County of Bernalillo
State of New Mexico
Public Works Division

Date: June 16, 2022

Subject: Bernalillo County Regional Recreation Complex (BCRRC), Mesa del Sol Traffic Impact Study

Below are Bernalillo County comments on the subject draft TIS dated April 18, 2022. Please address these comments for the subsequent submittal.

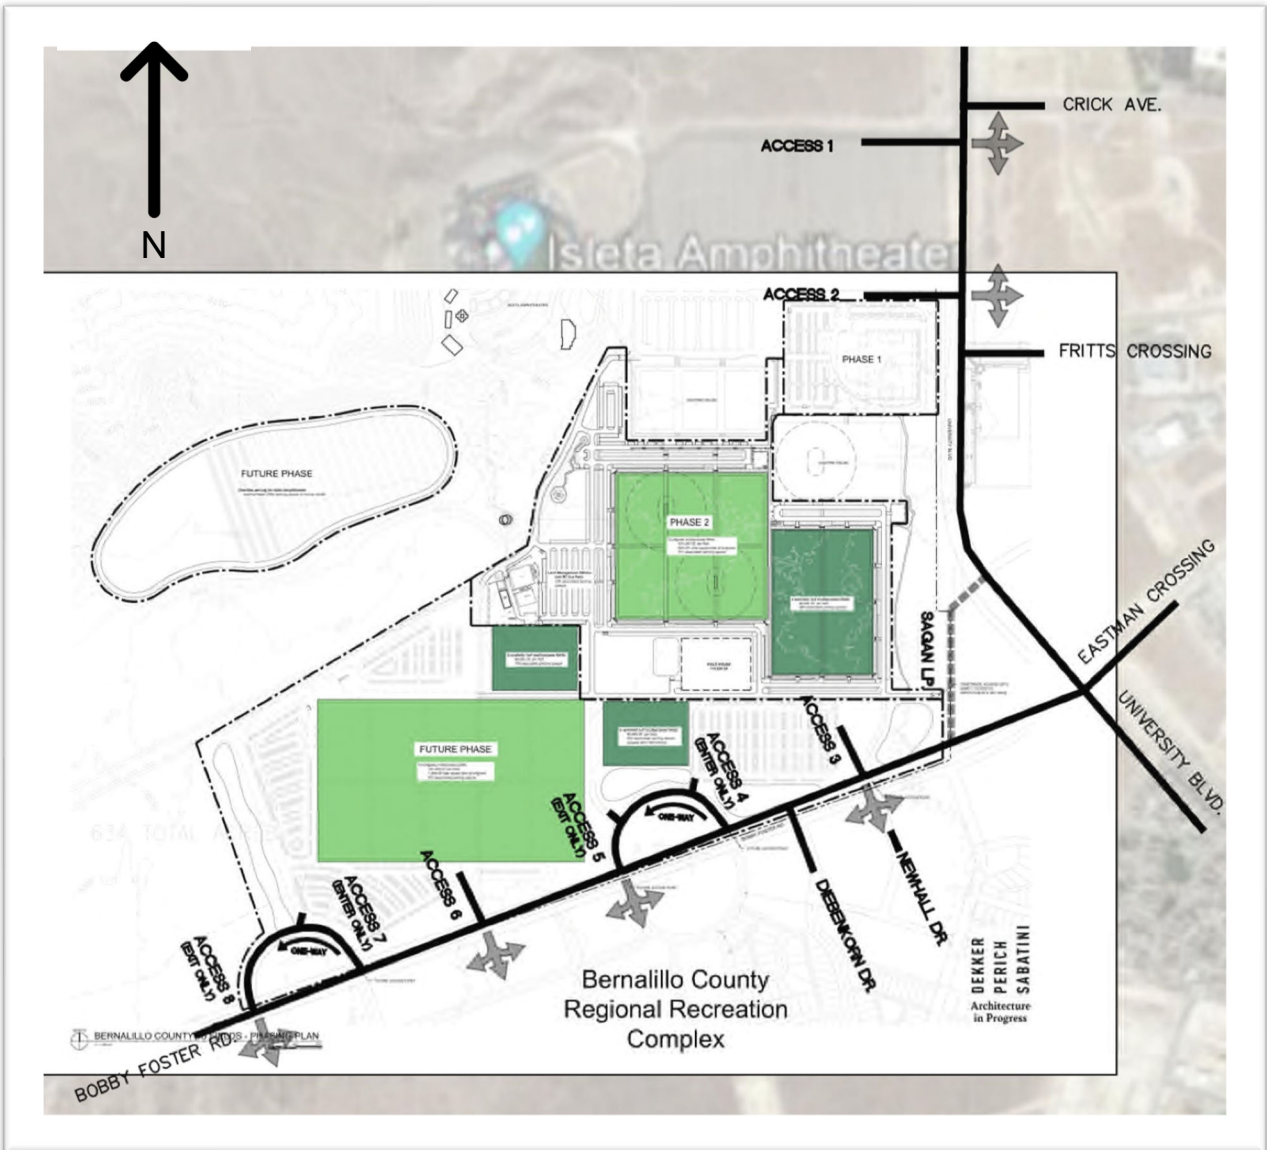
- 1. Page iv (Vicinity Map), Page 3, A-2 (Site Plan) – Please provide a legible image where the 1-3 phases and the associate generators (fields or offices) can be seen on the map. There is conflicting information on the site plan with symbology showing Access 5 & 8 as full access, but notes stating that each is either exit or enter only. The pages detailing each intersection provide images of this site plan with incorrect access arrows. These pages need to be updated as well. **The map has been updated.**
